Subject: FW: Planning Consultation on: Y/15/21/DOC Land North of Yapton Primary School

From: Laura Gibbons <Laura.Gibbons@arun.gov.uk>
Sent: 09 March 2021 11:58
To: Planning.Responses <Planning.Responses@arun.gov.uk>
Cc: Simon Davis <Simon.Davis@arun.gov.uk>
Subject: RE: Planning Consultation on: Y/15/21/DOC

Condition 9- surface water drainage strategy

Job Title	LAND AT STAKERS FARM, YAPTON
Drawing Title	PERMAVOID CONNECTION CHAMBER

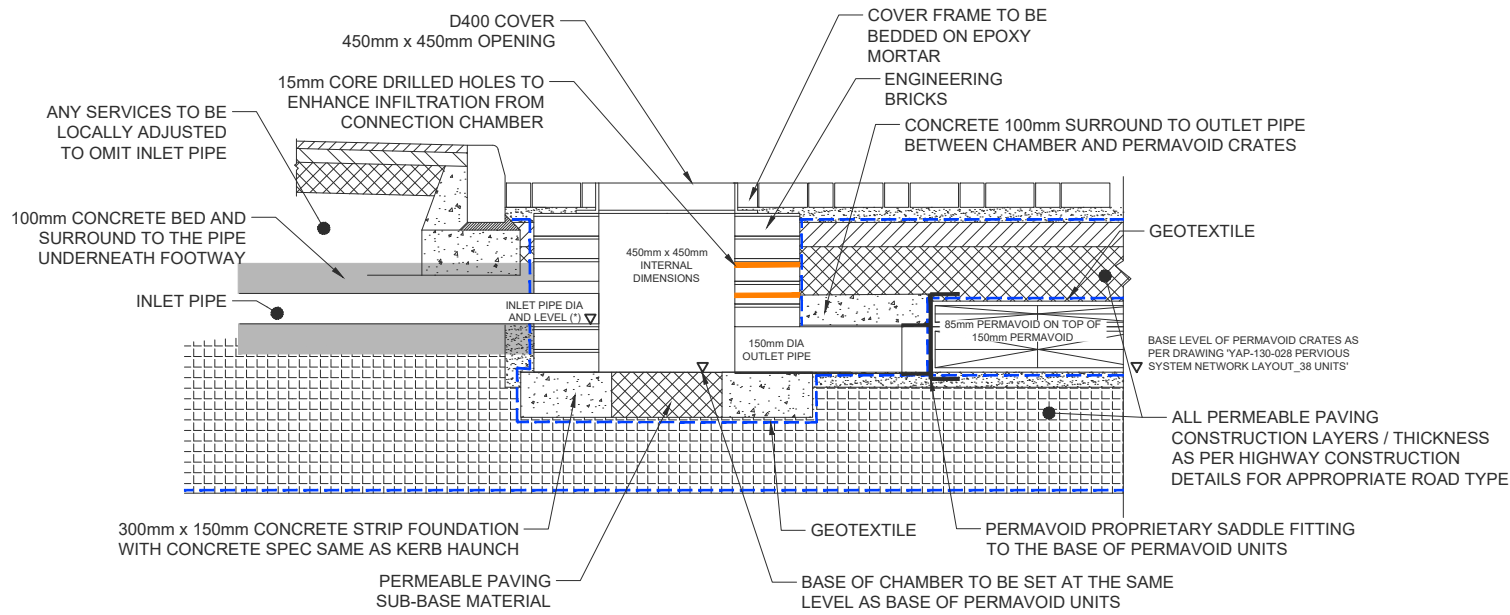
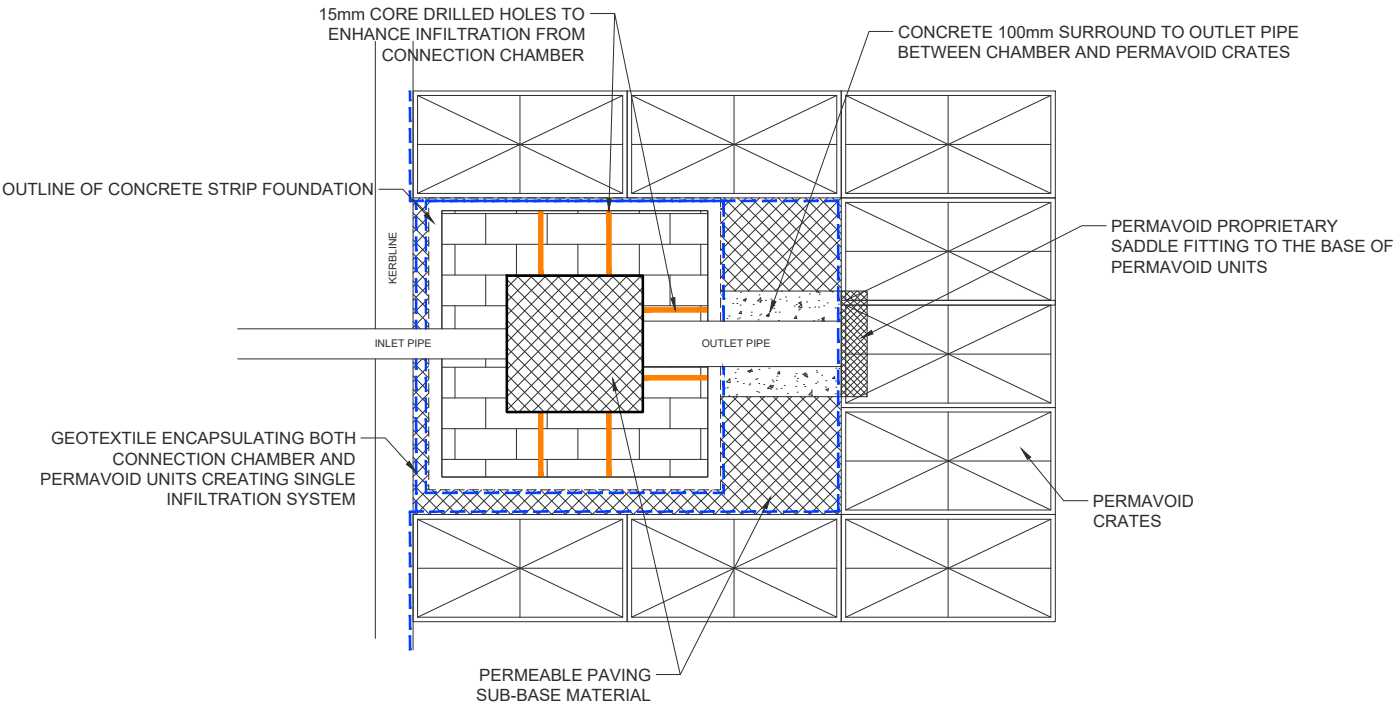
11. Road type 2 which drains plots 23, 25-27 appears to have incoming invert levels at the base of the structure, rather than above the 1 in 10 year plus cc water level. Please revise. Drainage design updated. Please see drawings YAP-130-082C2 and YAP-180-031C2. The actual connection into the Permavoid must be constructed at the base due to the proprietary saddle connection fitting part, however the surface water (SW) system is designed so the last SW chamber (silt trap) is above the 1 in 10 years plus cc water level within permeable paving system, i.e. SW system is not lower than 5.995m AOD, which is a water depth of 0.16m (please see Road 2 with plots 23,25-28_1 in 10 yrs with CC_Rev_B calculations) for the storm design event added to the permeable paving base level of 5.835m AOD.

The same will apply to Road 3, where final connection into Permavoid must be constructed at the base due to the proprietary saddle connection fitting part. In this instance the water depth for the 1 in 10 yrs plus cc event is 0.288m (please see Road 3 plus plots 29-32_1 in 10 yrs with CC_Rev_C calculations) and with permeable paving sub-base level of 5.430m AOD (measured at the downstream end of Road 3, please see drawing YAP-130-028C1) results in the design water level of 5.718m AOD. We have designed last SW chamber (silt trap) prior to Permavoid connection to be not lower than this level and downstream pipe do not have any additional connection thus serves as connection conduit only with the actual SW system not being subjected to surcharge during the 1 in 10 yrs plus cc event. *Unclear on where any alterations to design have been made, incoming invert levels and formation levels appear the same.*
